Whitestone Solar Farm

Planning Inspectorate Application ref. EN0110020

Appendix A – Applicant's response to Section 51 and Section 55

DRAWING REFERENCE: EN0110020/APP/2.9.1

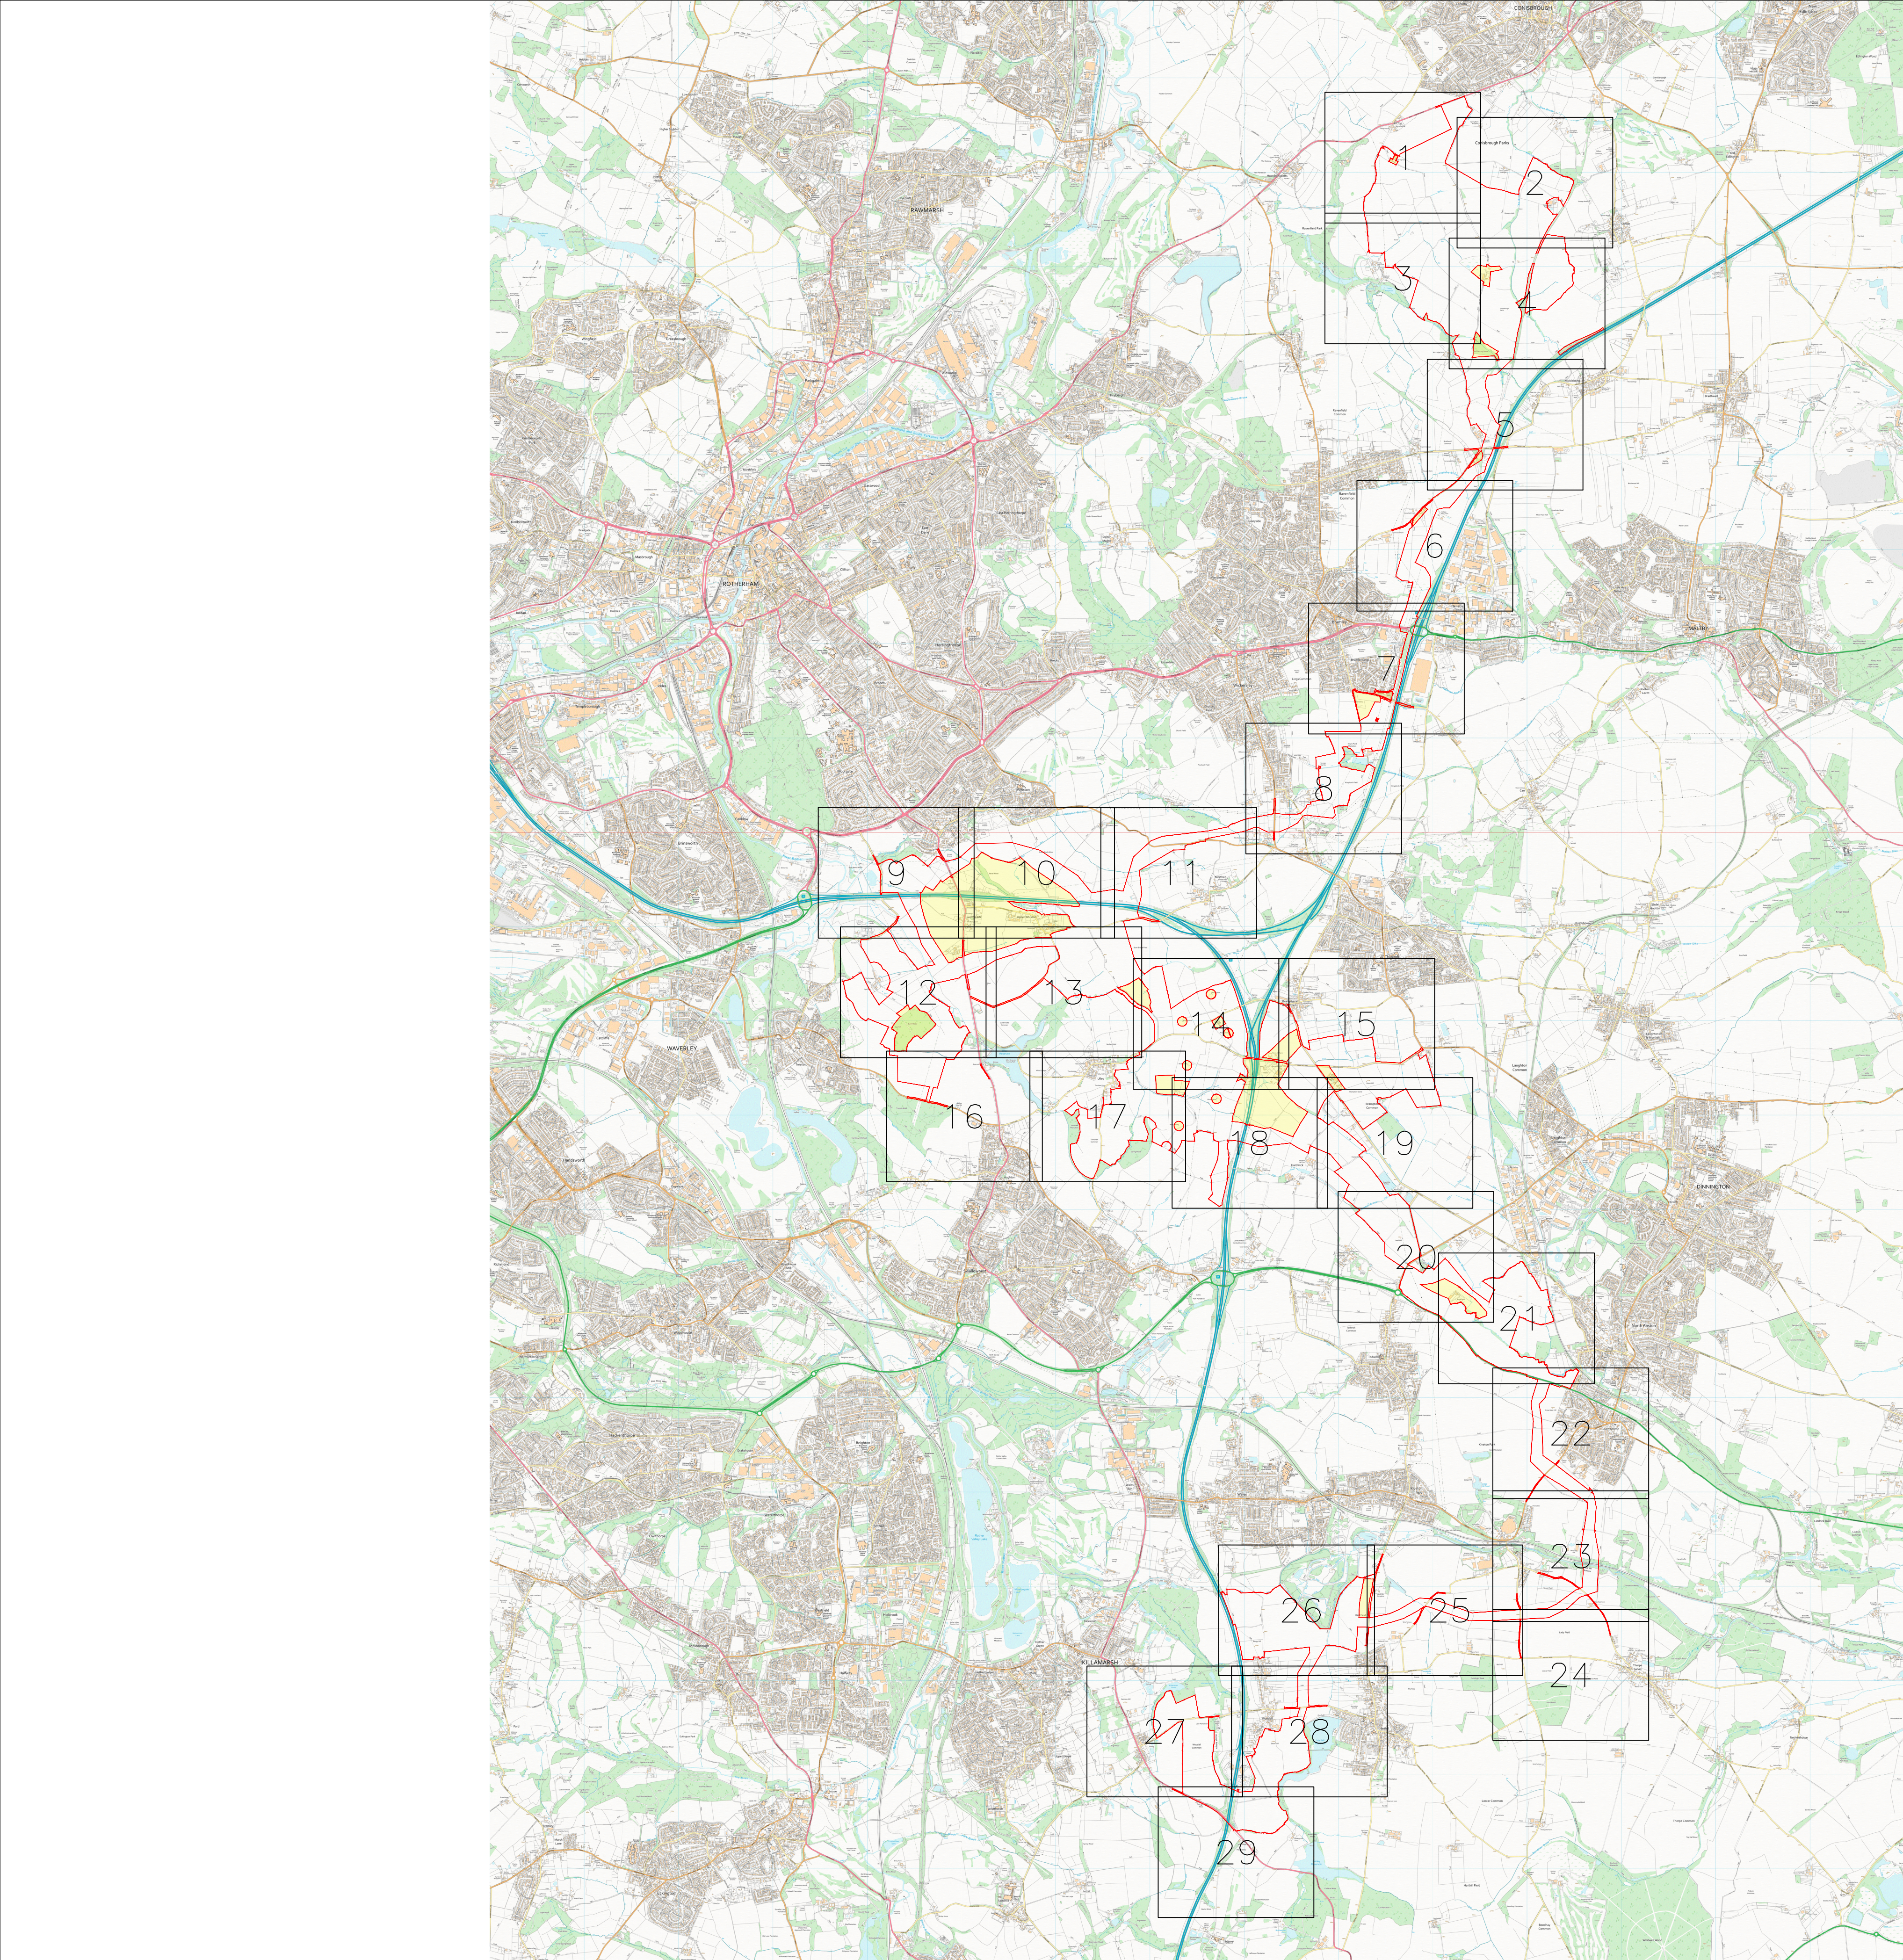
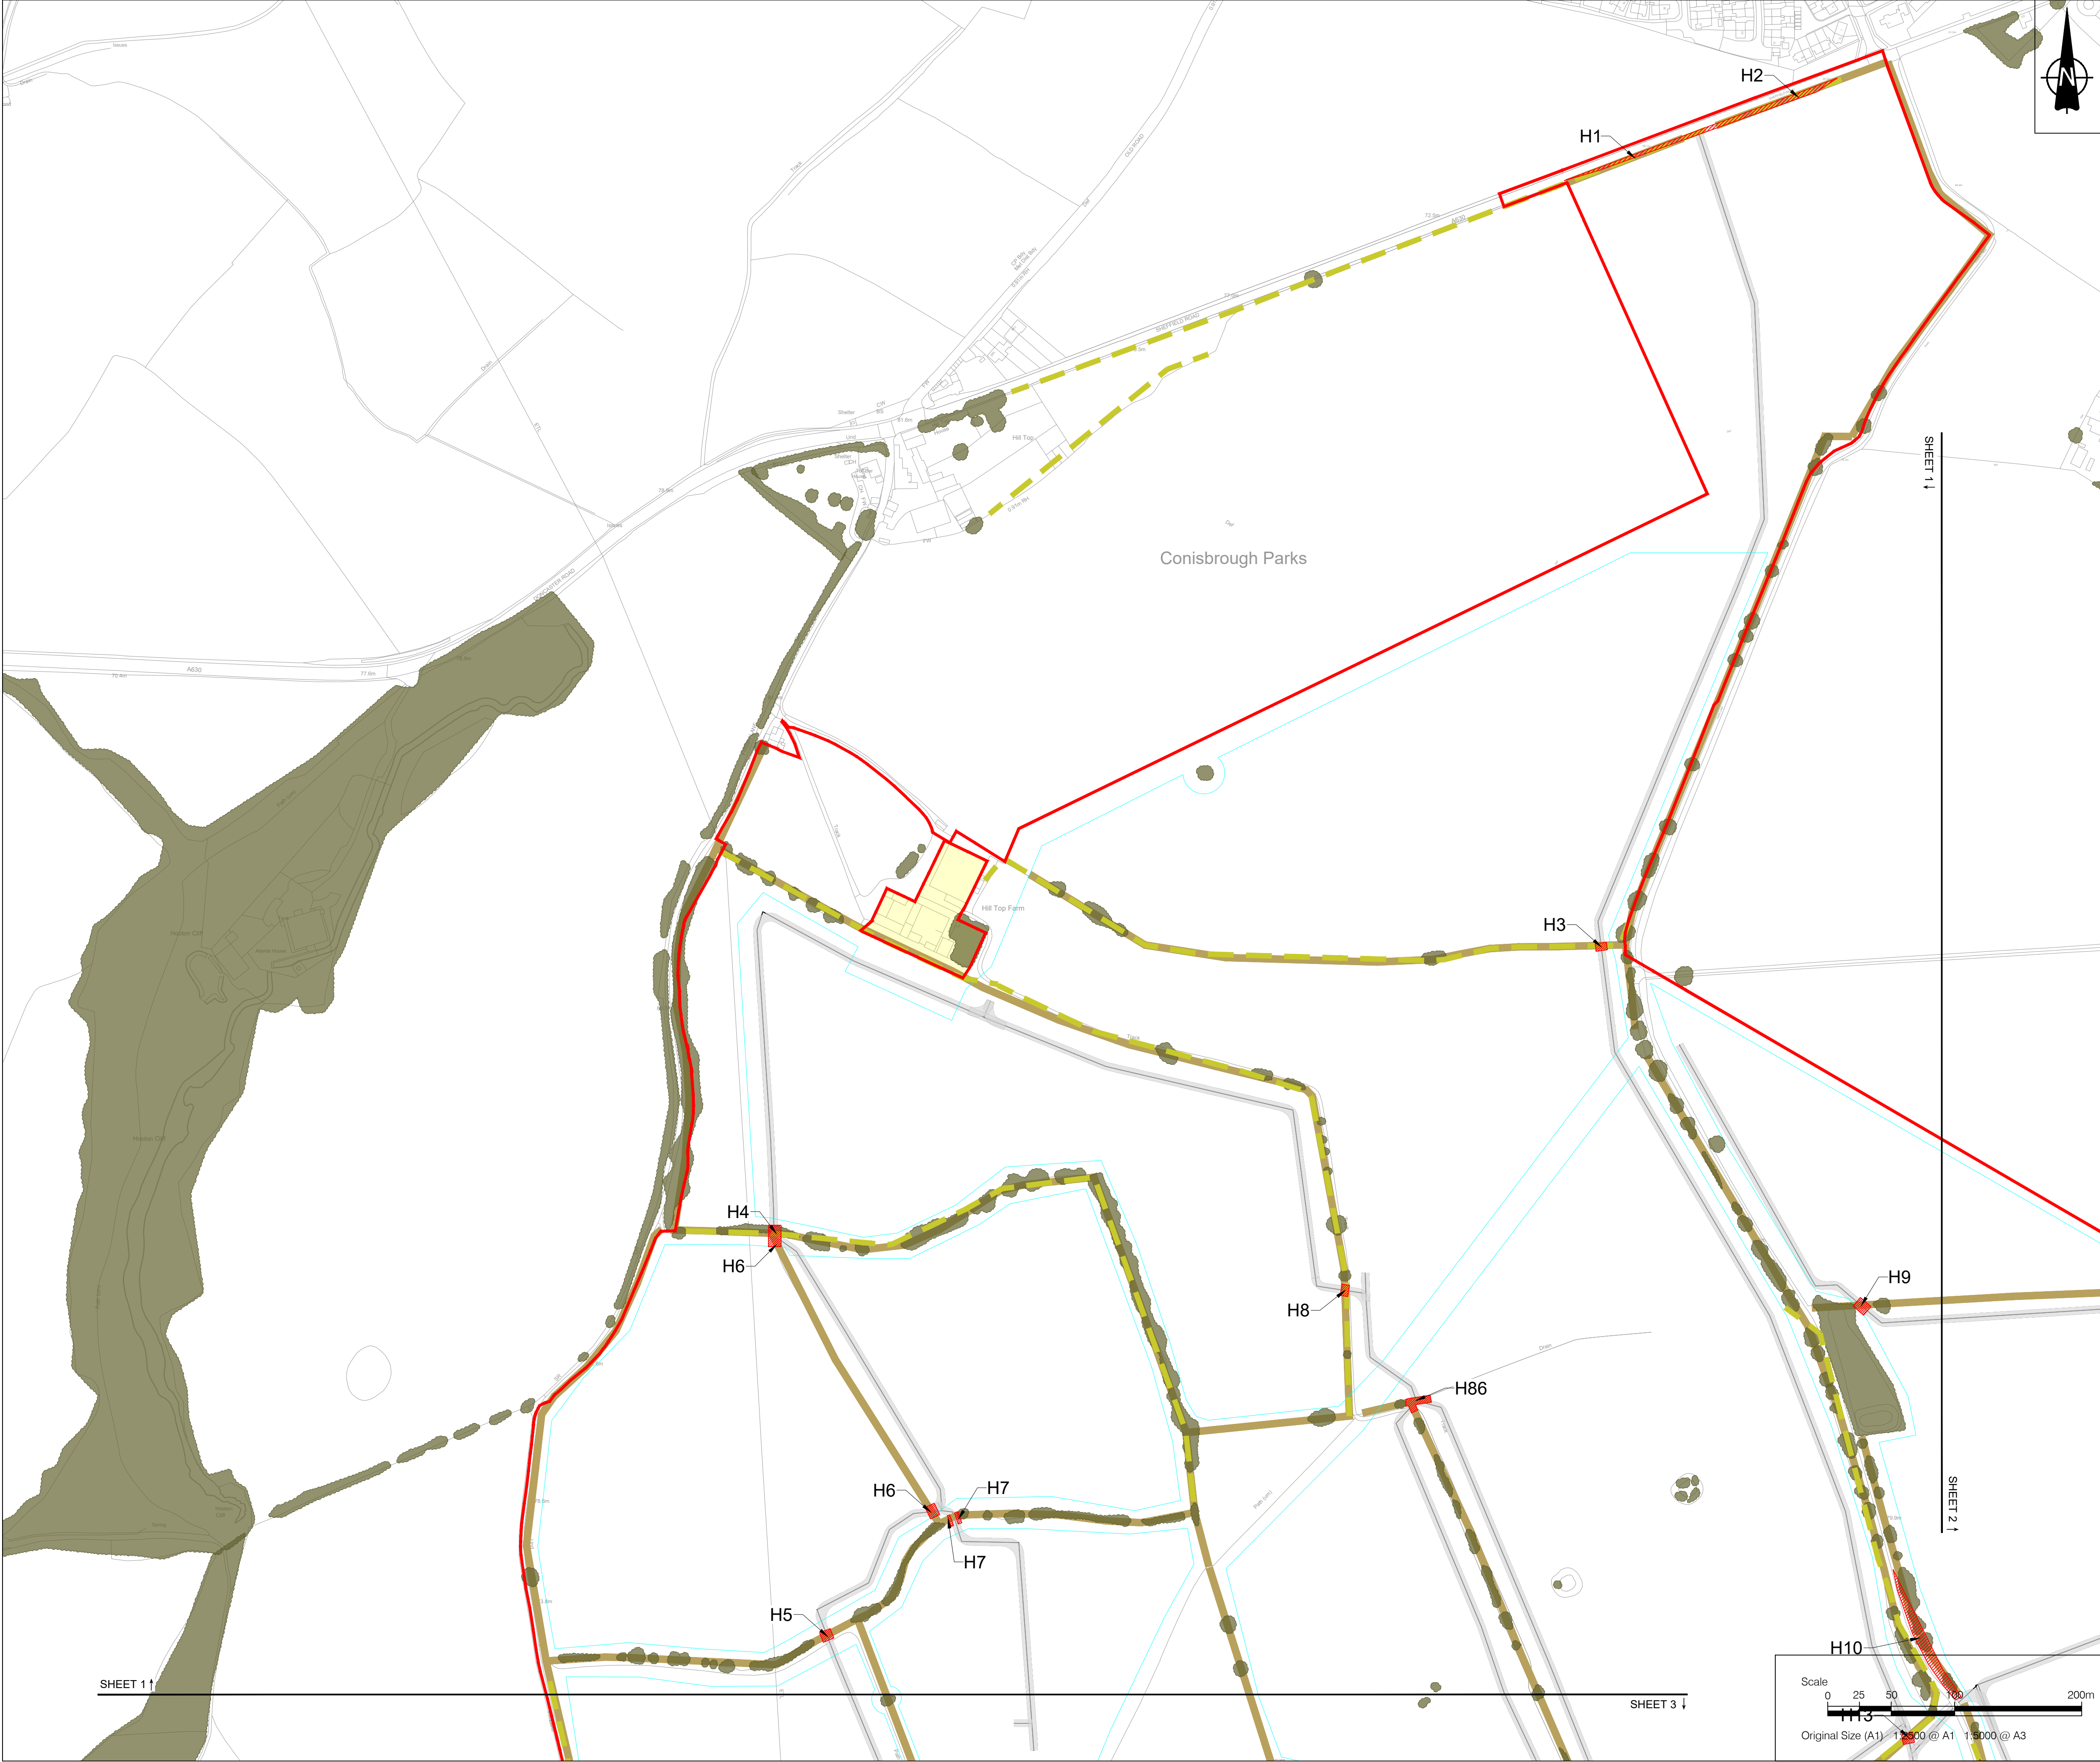
of Changes to the draft Development Consent Order [EN0110020/APP/8.1].	Schedule of Changes to the draft Development Consent Order [EN0110020/APP/8.1].
	Outline Public Rights of Way Management Plan (Doc 5.12) references referred to need to be checked throughout the document.	The Applicant notes this request, but the Outline Public Rights of Way Management Plan is document ref. 5.14 (APP-047). The Applicant has reviewed this document in accordance with the comment and noted no updates were required. However, while reviewing the Applicant also reviewed the Outline Construction Traffic Management Plan (document ref. 5.12) and updates were subsequently required to ensure all references were correct.	Updated Outline Construction Traffic Management Plan [EN0110020/APP/5.12.1] (clean and tracked).
	Location Plan (Doc 2.1) and Vegetation Removal Plans (Doc 2.9) it would be useful for these plans to show land excluded from order limits.	The Location Plan and Vegetation Removal Plans have been updated to show land excluded from the Order Limits in a yellow colour.	Updated Location Plans [EN0110020/APP/2.1.1] (clean and tracked). Updated Vegetation Removal Plans [EN0110020/APP/2.9.1] (clean and tracked).
